STRATEGIC HOUSING DEVELOPMENT
PLANNING APPLICATION
**RESPONSE TO AN BORD
PLEANALA OPINION**
FOR LANDS AT HOLLYSTOWN-KILMARTIN, DUBLIN 15

Response to ABP Opinion

Project No. 6733
Client: Glenveagh Homes Limited
Project Name: Lands at Hollystown-Kilmartin
Report Name: Response to An Bord Pleanala
Document No. RPSC01
Issue No. 02
Date: 09/12/2021

Drawing Title: Site Plan - Area Taken in Charge

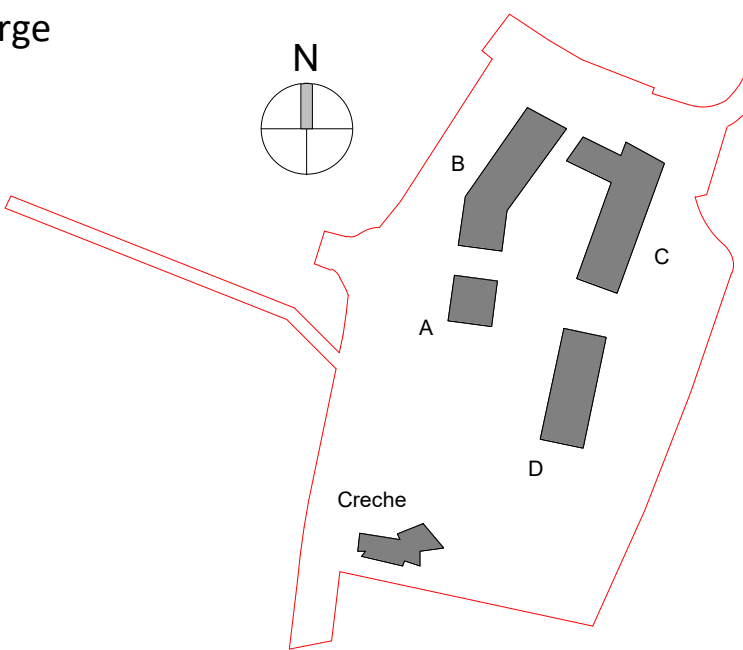
A site layout plan indicating what areas, if any, are to be taken in charge by the planning authority.

Please see enclosed Taking in Charge Drawing '19072C-OMP-00-SP-DR-A-1010 Site Plan- Area Taken In Charge' prepared by O'Mahony Pike Architects, in respect of the Local Centre lands.

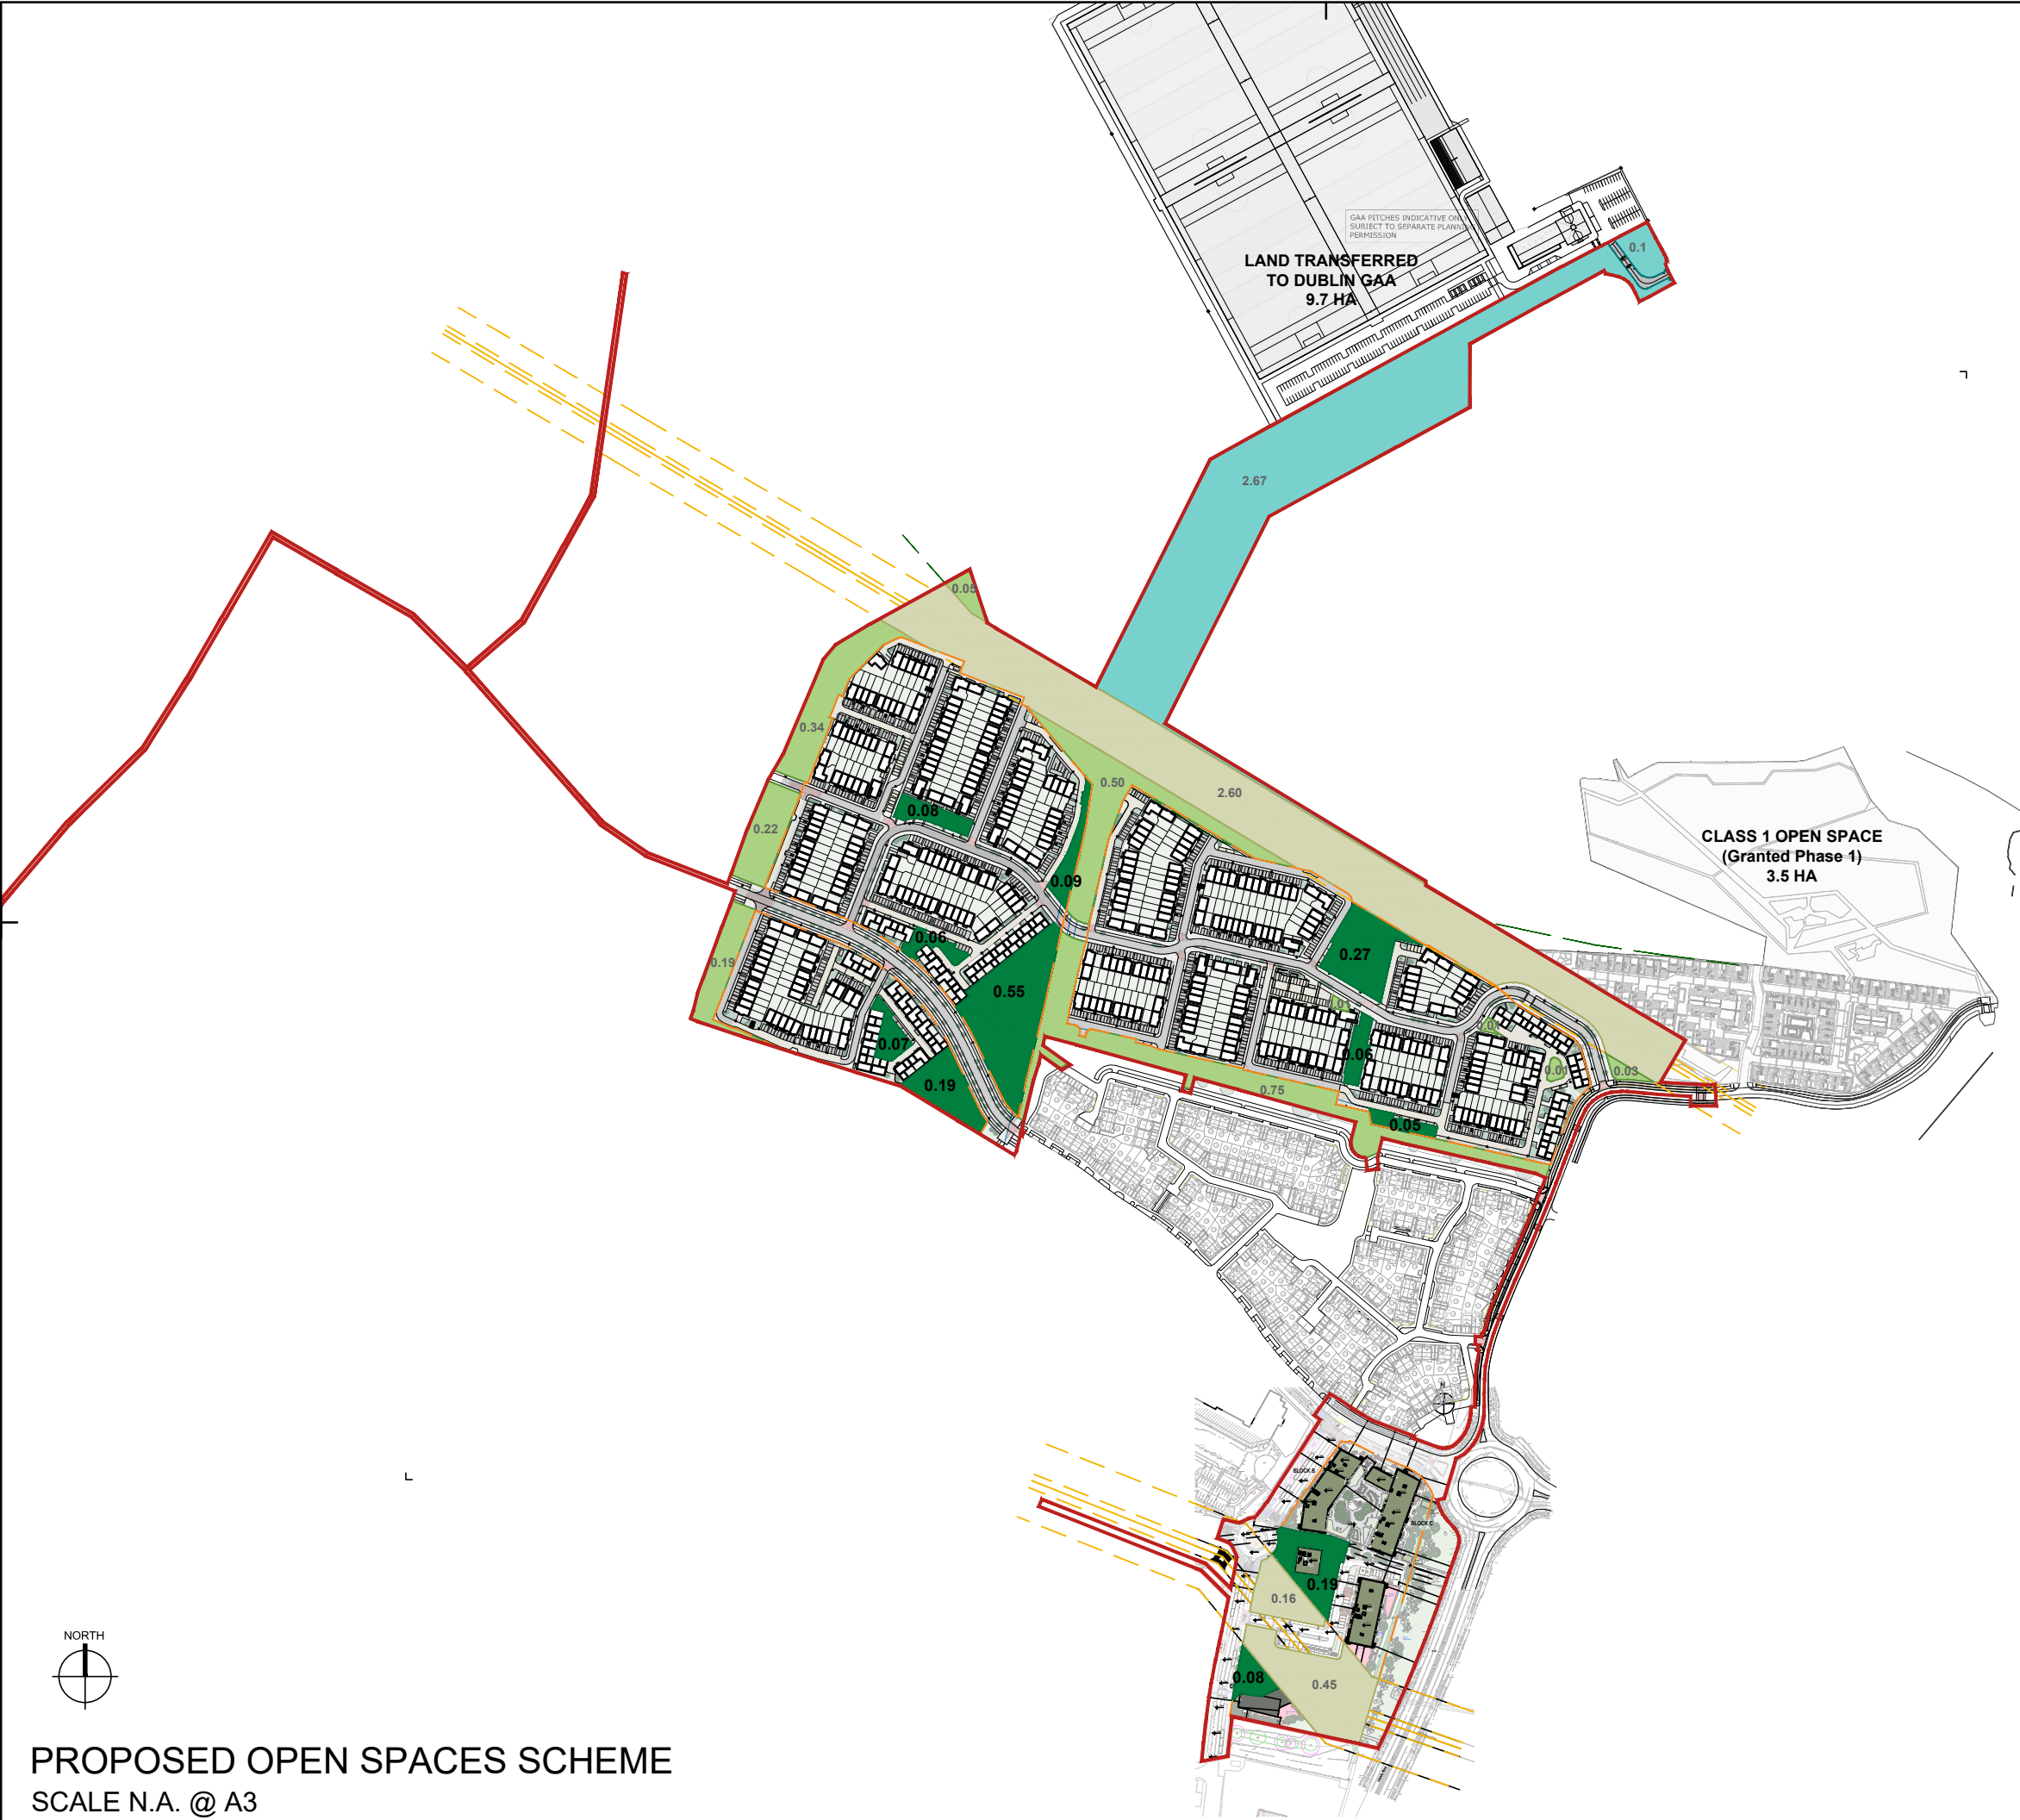
Justification of hierarchy and quantum of open space provision, both communal and public open space (POS). Clarity with regard to compliance with Development Plan standard and location of underground attenuation tanks and storage systems under public open space, as part of SuDS solution. A response to the contribution suggested by the planning authority in accordance with Section 48(2) (c) of the Planning and Development Act 2000 in lieu of public open spaces provision.

This application for development meets and exceeds requirements for both communal and public open space.

Justification for the provision of the public open space is set out in the BSM Framework Plan for Hollystown Kilmartin which sets out open space provision in

the context of the wider landholding of Glenveagh Homes. It is further set out within the OMP Architects Design Statement and the BSLA Local Centre Landscape Design Statement.

Justification for the provision of communal open space is set out in the OMP Architects Design Statement and further detailed in the BSLA Local Centre Landscape Design Statement.

The DBFL Infrastructure Design Report sets out the SuDS solution for the application lands and its interface with open space. This is further detailed in the BSLA Local Centre Landscape Design Statement, as it pertains to the local centre lands.

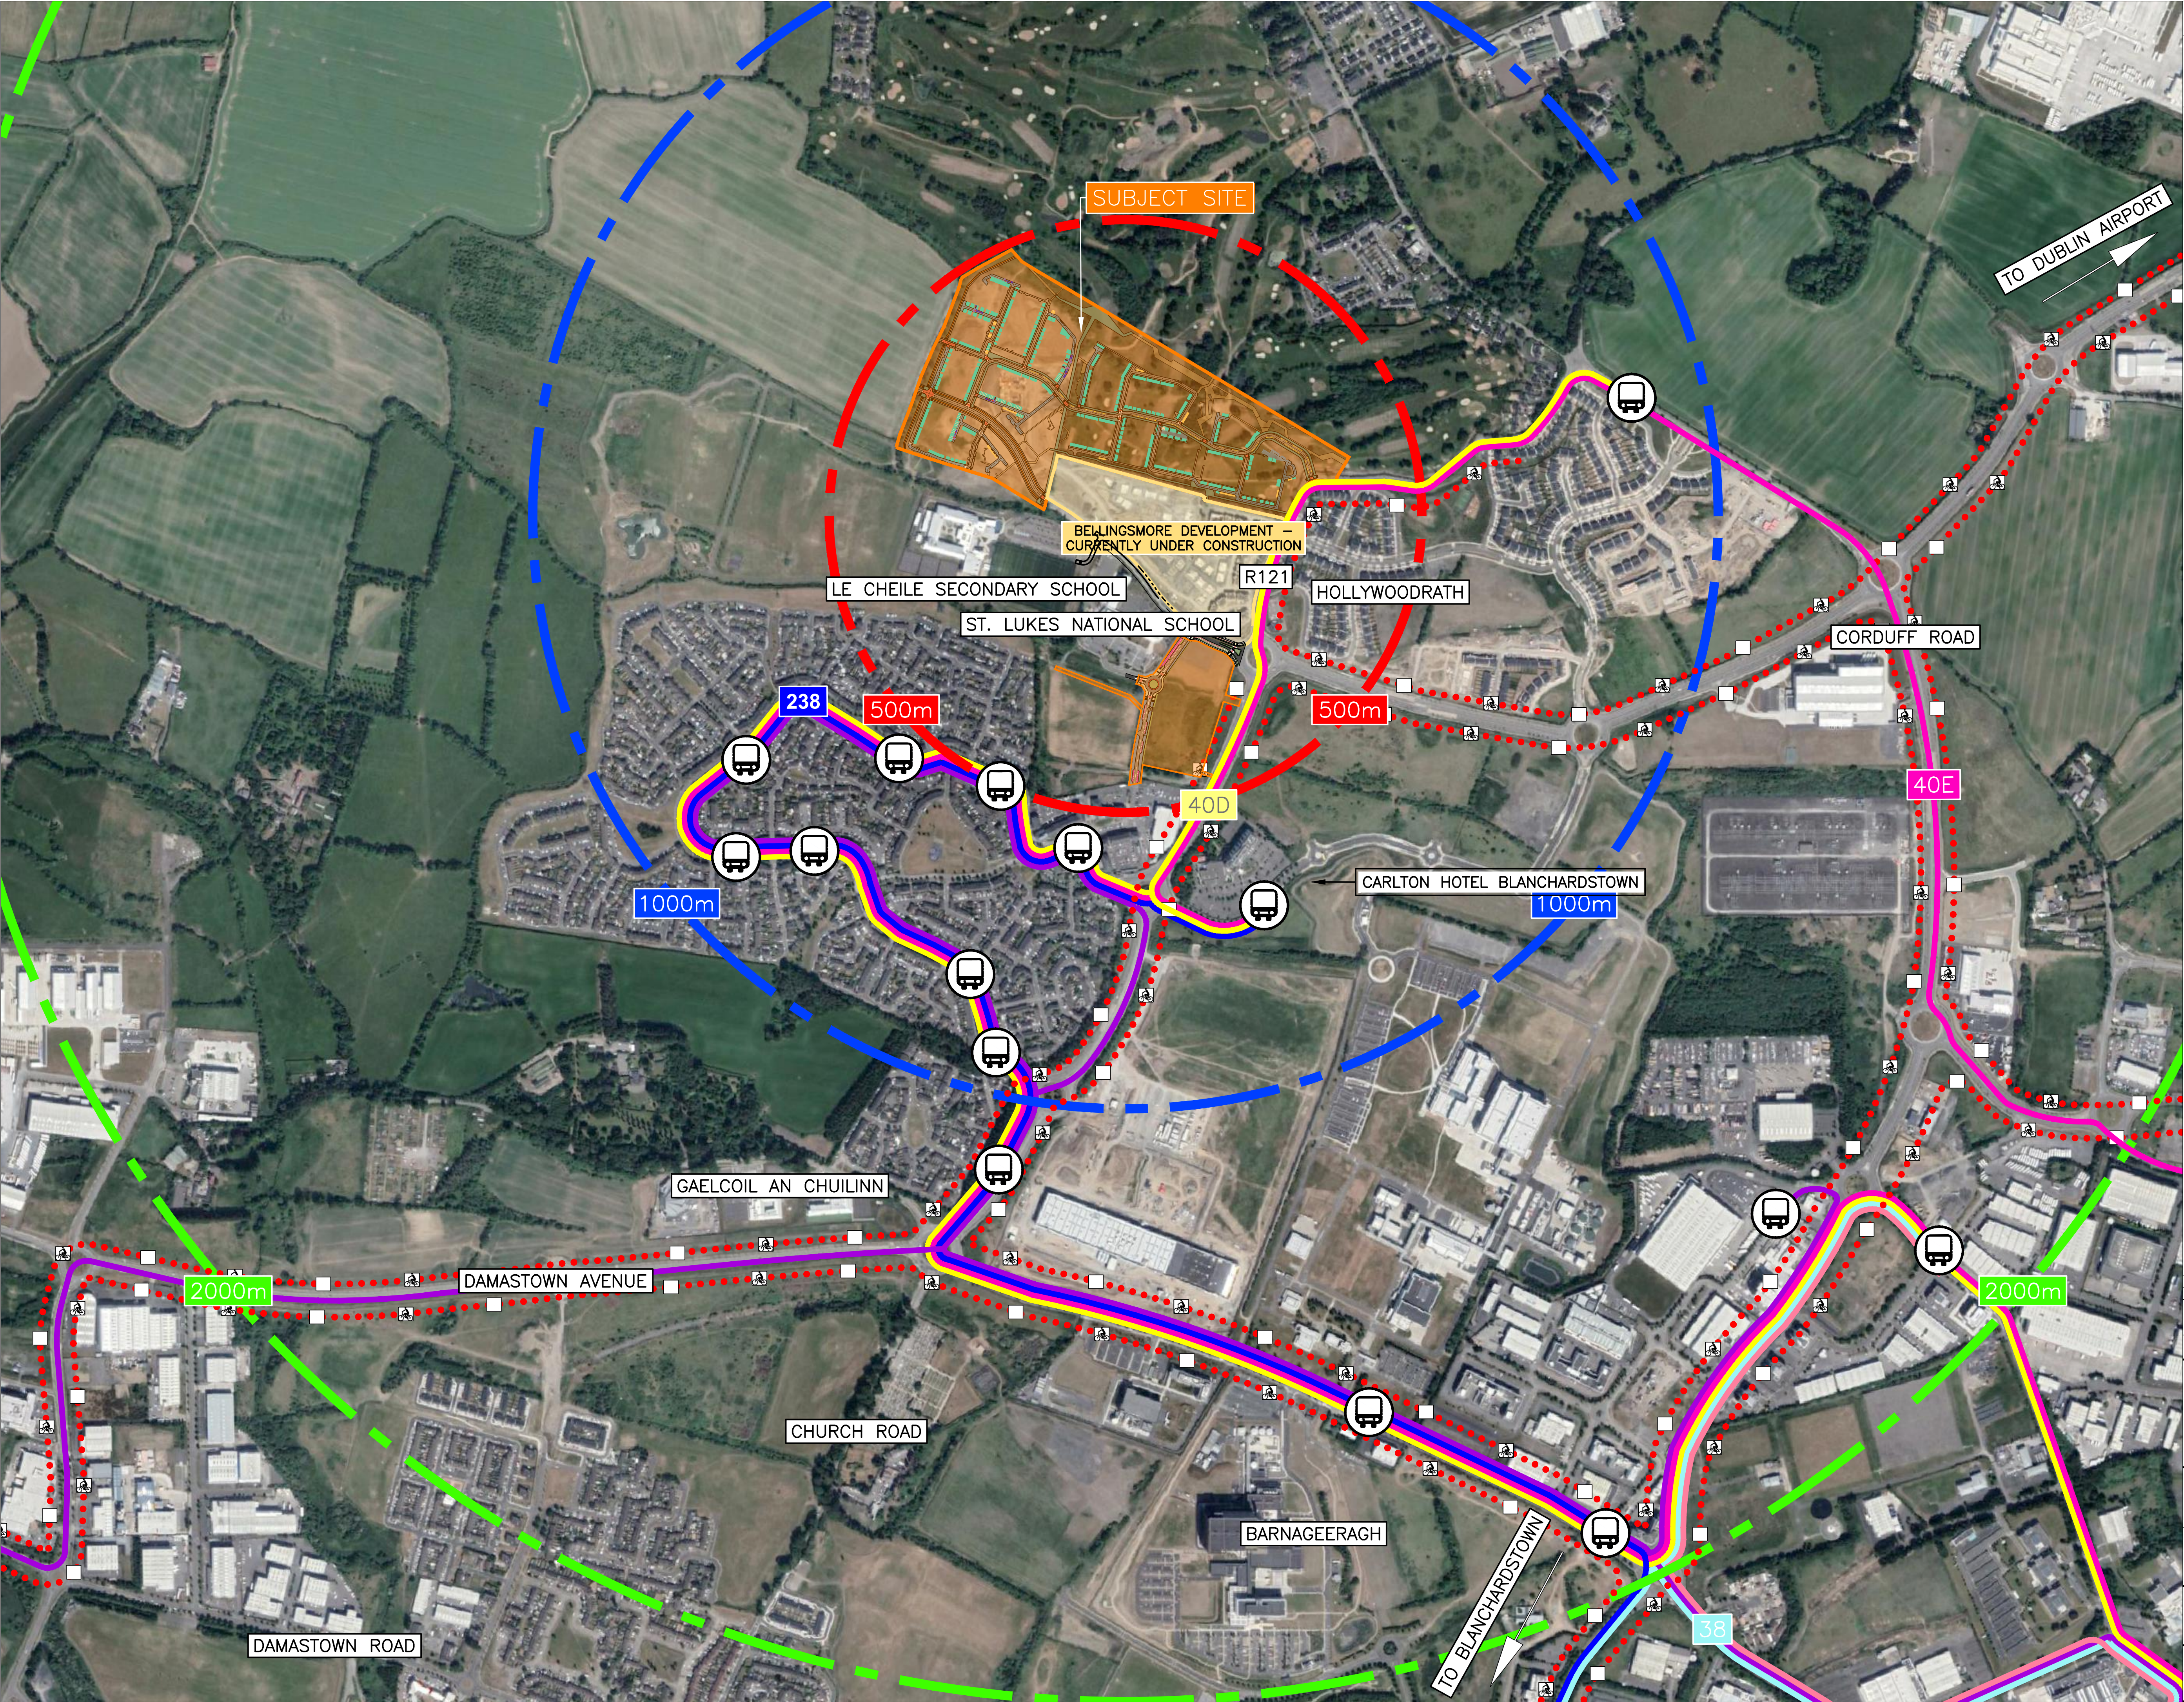
Further clarity on possibility of rerouting the Bus network and provision of a Bus Stop within any future proposal for the Local Centre. Details of discussion with National Transport Authority and other relevant bodies

Section 4.2 of the DBFL Traffic and Transport Assessment Report sets out details and considerations for rerouting of bus network through the Local Centre, and the potential for provision of a bus stop on the new Link Street being delivered.
